13 June 2014

File No: MP10_0048 MOD 4
Our Ref: R/2010/580/C

**RE: City's submission to Barangaroo Headland Park Section 75W
Modification, Demolition of former Sydney Ports Harbour Control Tower**

**Figure 6:** Plan showing extent of demolition works (HCT) and new construction. (Source: WMK Architecture)

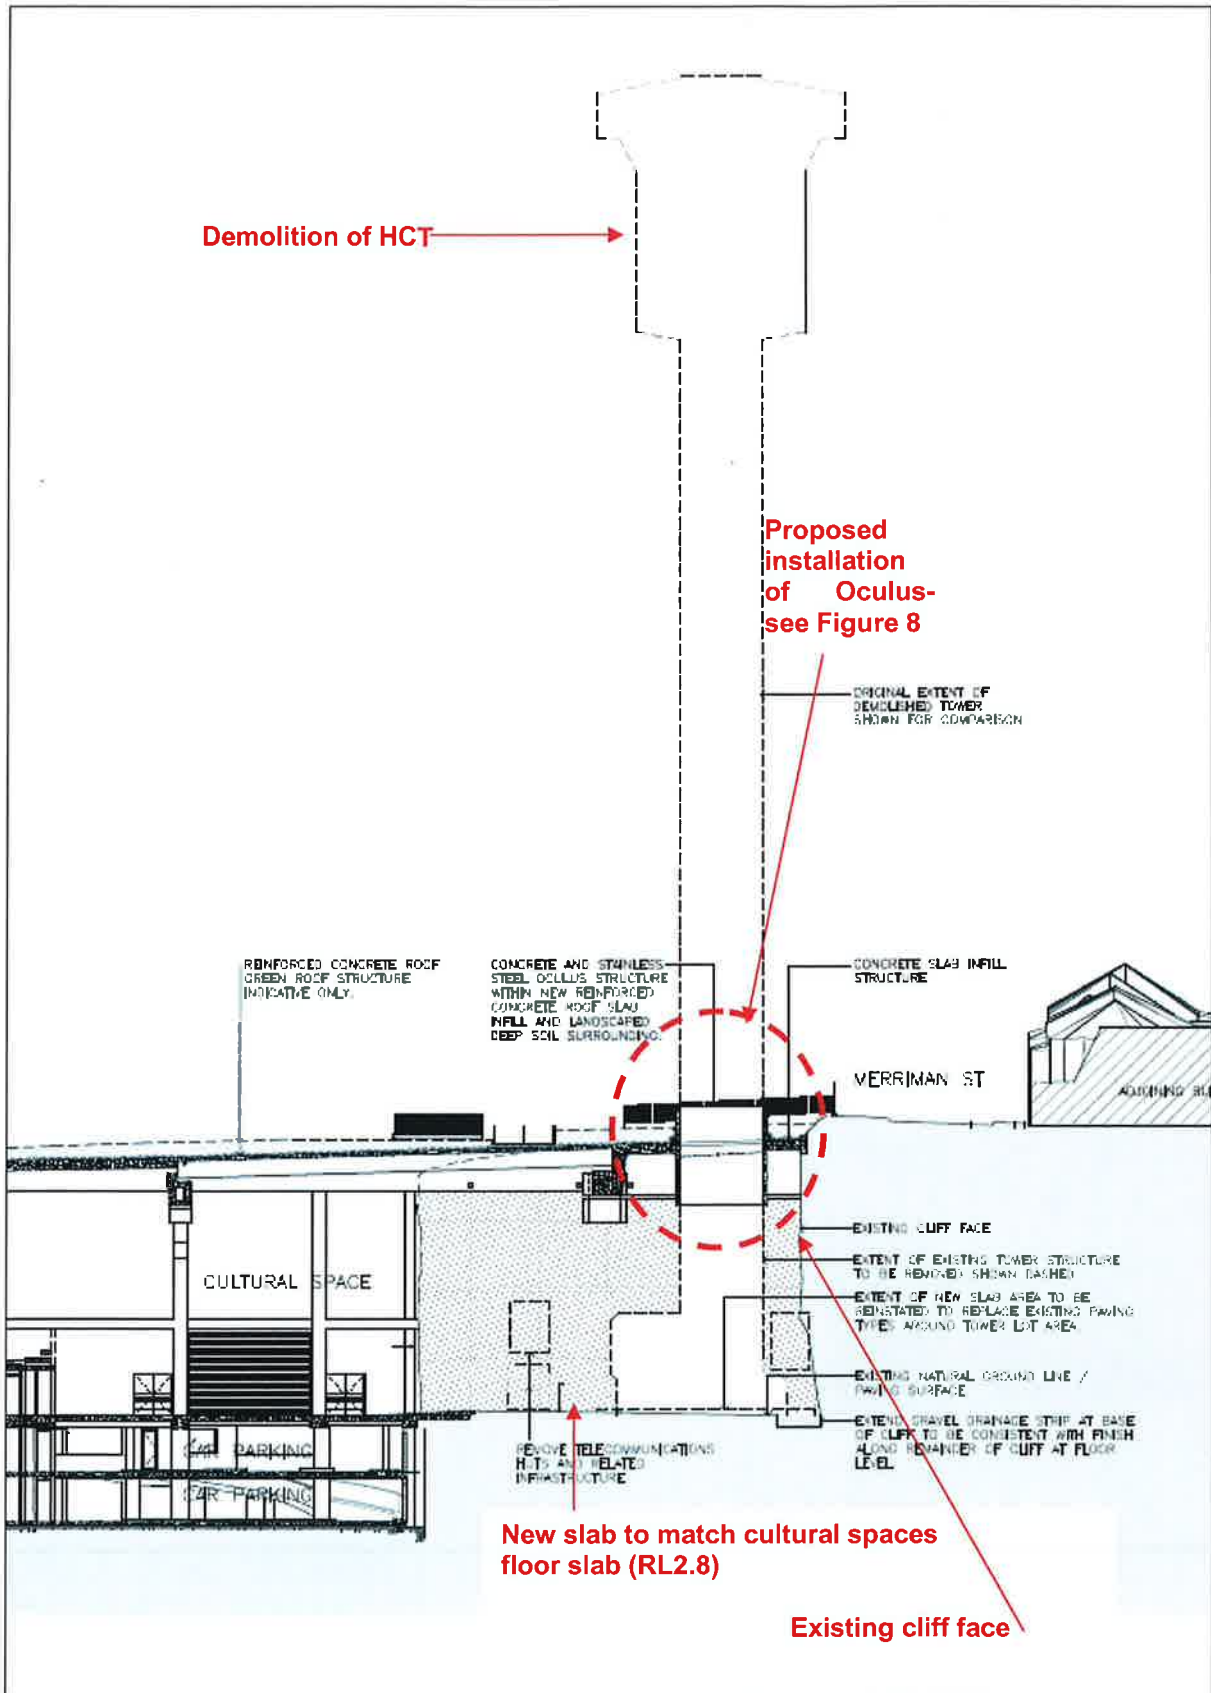
If the Agency is minded to approve the request to demolish the Tower, the detailed design of this opening requires further refinement as follows:

- Interpretation of the Tower should be included on the concrete wall upstand in addition to the new paths around the site. The introduction of interpretation on the wall would achieve greater visual impact;
- The proposal for a wall 1100mm-1320mm high surrounding the void opening has safety implications in the event that a visitor climbs the wall and is unable to get out of the void; and
- The skylights shown on the drawings are inconsistently located and this should be clarified in the documentation.
